**17625 Person Drive, AL-24-11**

**Please accept the following comments from El Paso County Public Health for the project referenced above:**

New Ag Bldg.

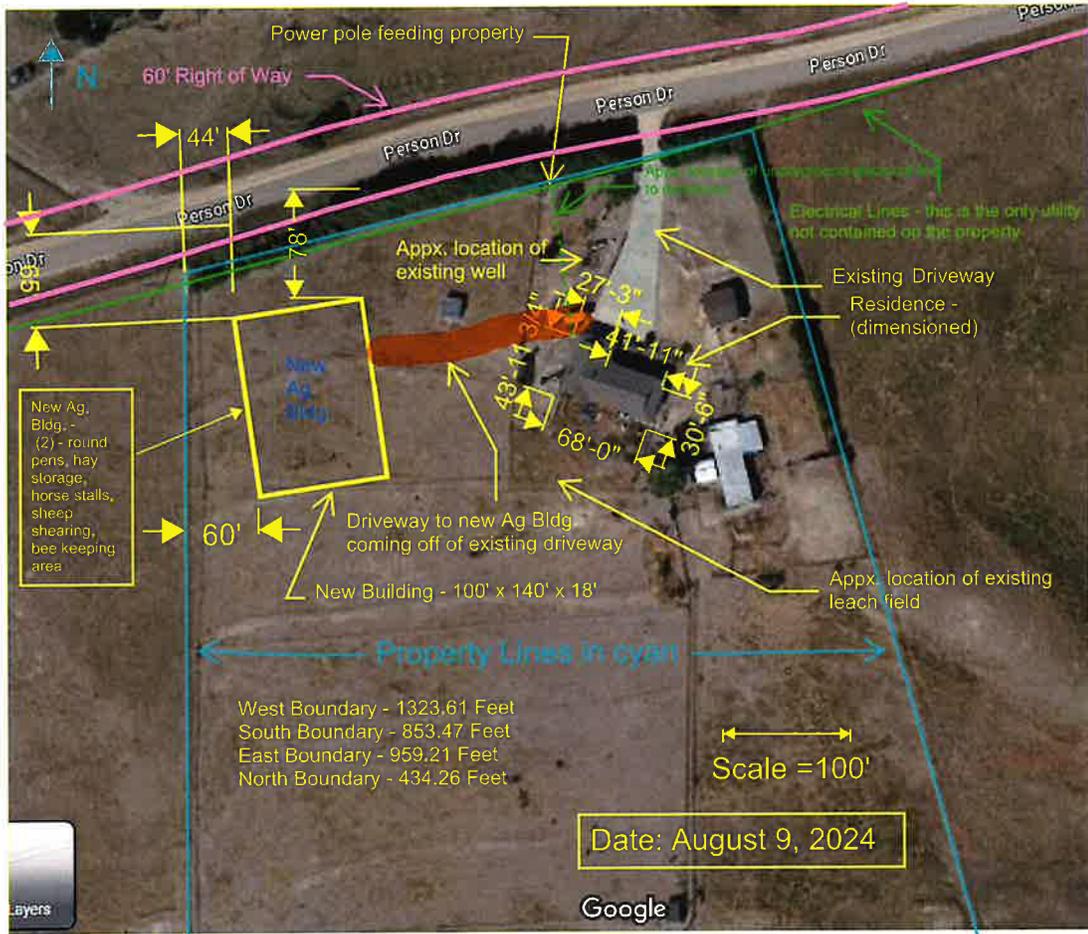
- **The property has an existing onsite wastewater treatment system (OWTS) that was permitted and installed for a 4-bedroom house in 1985. The soil treatment area (STA) for the existing house must be located and protected from compaction associated with the construction of the proposed 14,000 sq.ft. structure.**
- **If an OWTS is planned for the structure, then a New OWTS Permit is required.**
